Case Officer: Hannah Kersley
Reference: BR/46/22/T
Location: 43B Pevensey Road, Bognor Regis, PO21 5NY
Proposal: Remove 4 lower limbs of 1no. Corsican pine tree
Reason given: Tree unbalanced

REF 1

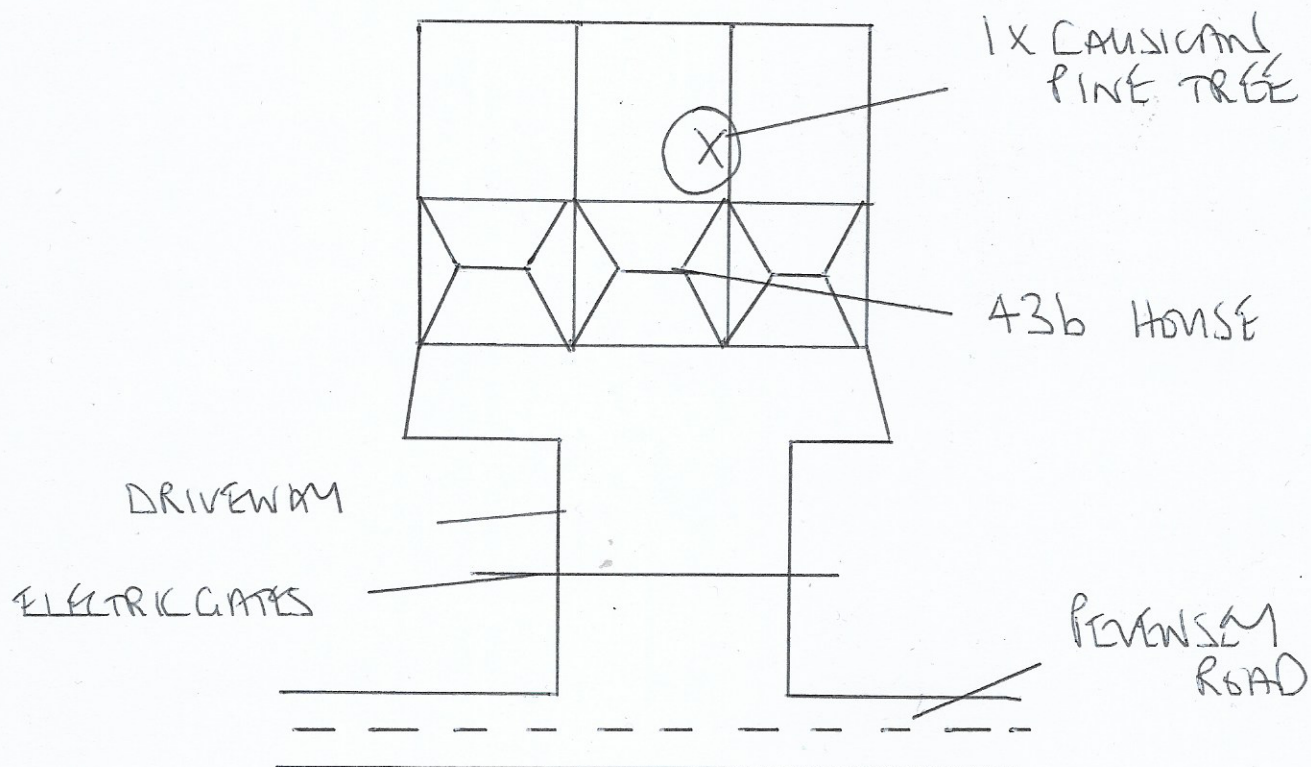
- The proposed work has not been justified on arboricultural grounds.
- The lower crown profile is asymmetric although this does not detract from the tree's amenity value or present as a nuisance.
- The removal of branches to balance the lower crown profile on all aspects does not meet the requirements in British Standard (BS3998:2010) Tree work – Recommendations. Such a loss in volume of needle-bearing branches would likely be harmful to the long-term health and vitality of the tree.
- The tree is a significant feature in the local landscape and appears to be in adequately sound and healthy condition. The tree surgery proposed in the application is likely to result in excessive reduction of the tree's landscape impact and undue detriment to the visual amenities of the locality.

- I recommend **REFUSAL** for this application.
